CITY OF ALBUQUERQUE

RE: Sierra Sunset Apts - 10600 Big Springs Rd. SW
Grading & Drainage Plan
Engineer's Stamp Date 4-10-2014 (File: N08D003c)

Based upon the information provided in your submittal received 4-10-14, the above referenced plan cannot be approved for Building Permit until the following comments are addressed:

SIERRA SUNSET PARK
GRADING AND DRAINAGE PLAN WEST

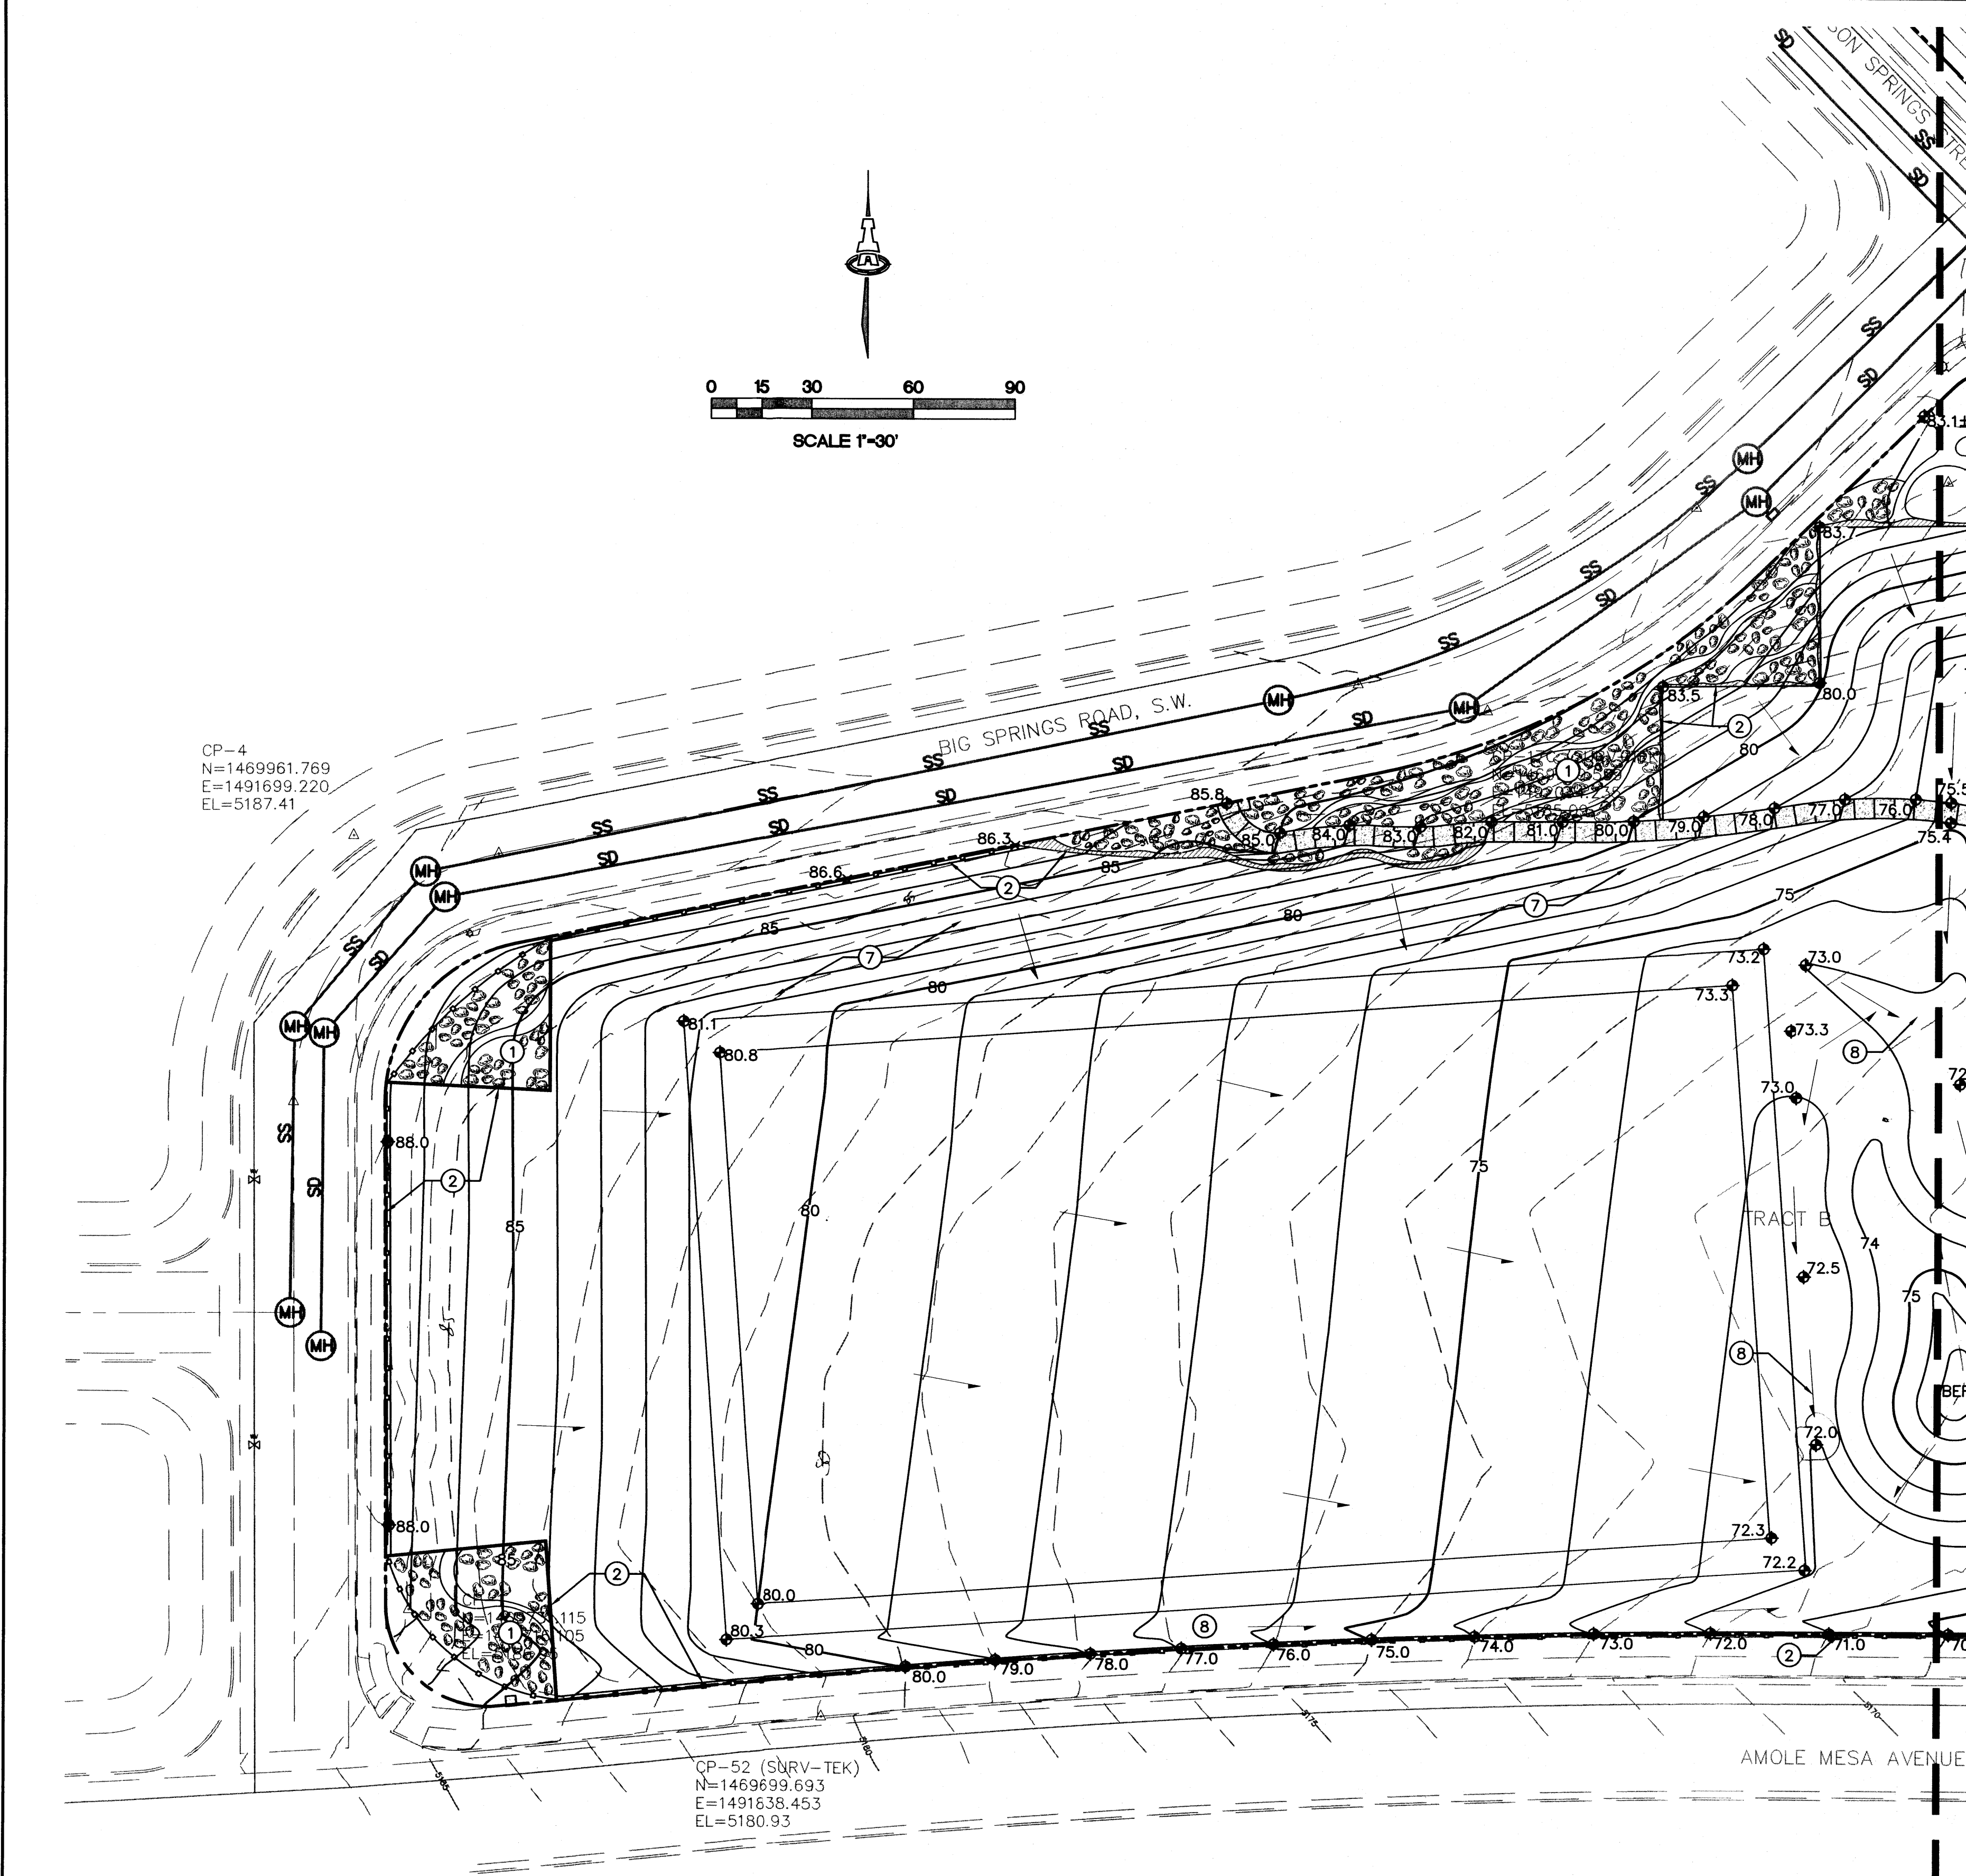
1. Show volume, MWSEL, Q100 for the proposed pond. In the calculation of pond volume, account for the volume of the landscaping boulders that would decrease the pond capacity.
2. AMAFCA must approve the plans before Building Permit approval can be granted.
3. Indicate what keyed note 9 is.
4. Show the existing contour elevations [values] so as to compare to the proposed contours.
5. Bench mark information is missing in the title block.
